Application # 0750018723R

PROPERTY LOCATION: Subdivision: Persimmon Hills Lot #: 75 Lot Size: .66 ac.

HOMECO BUILDERS
 THE CAMBRIDGE
 LOT # 75 PERSIMMON HILL
 SCALE: 1"=40'

Re: Status of Improvement Permit Application #07-5-18723
Persimmon Hill Lt 75

FOR SIMMONS HILL
 LOT 75
 07-500-18723

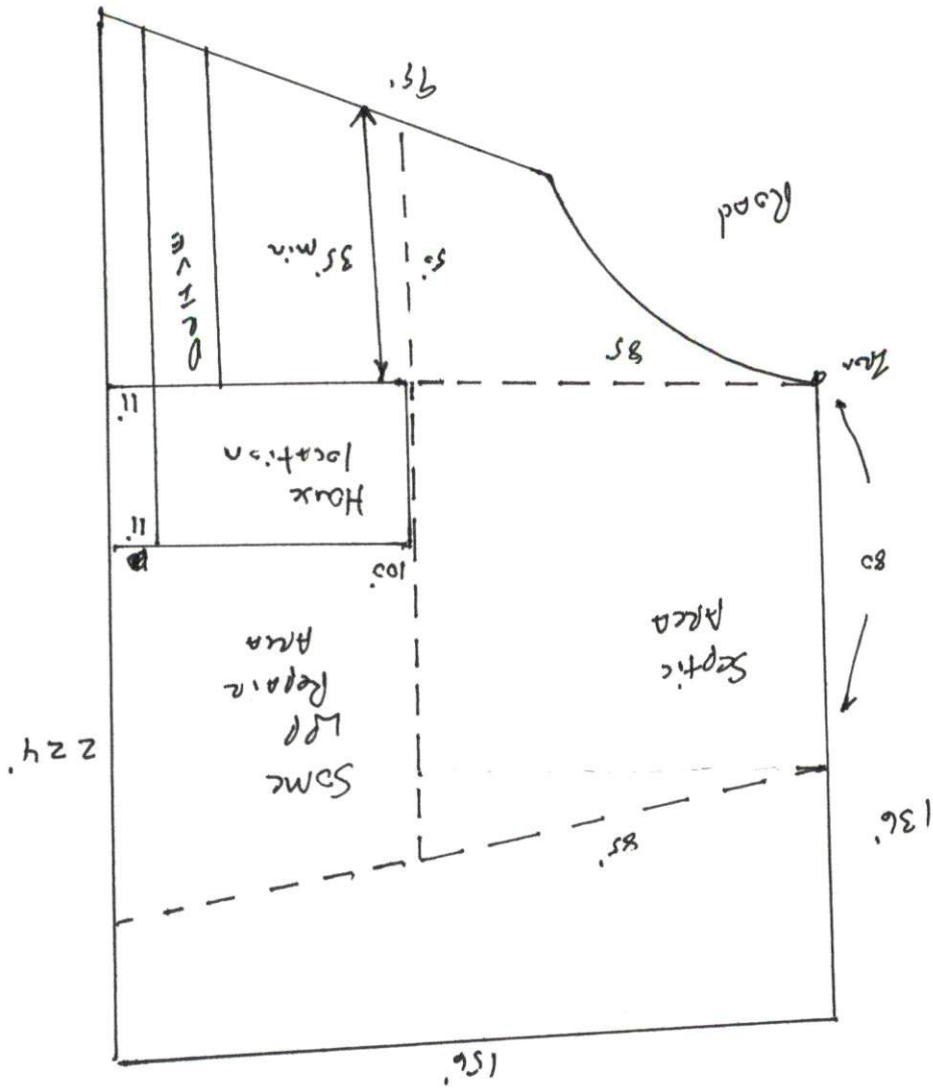
- 1. Property lines/corners not marked or labeled
- 2. House corners not marked or labeled
- 3. Directions not clear to property
- 4. Property needs brush or vegetation removed
- 5. Backhoe pits required
- 6. **Other – Move house as shown and submit new plot plan to Central Permitting.**

NOTE Change In house
and Drive location

Submit new plot

Plan To Central Permitting
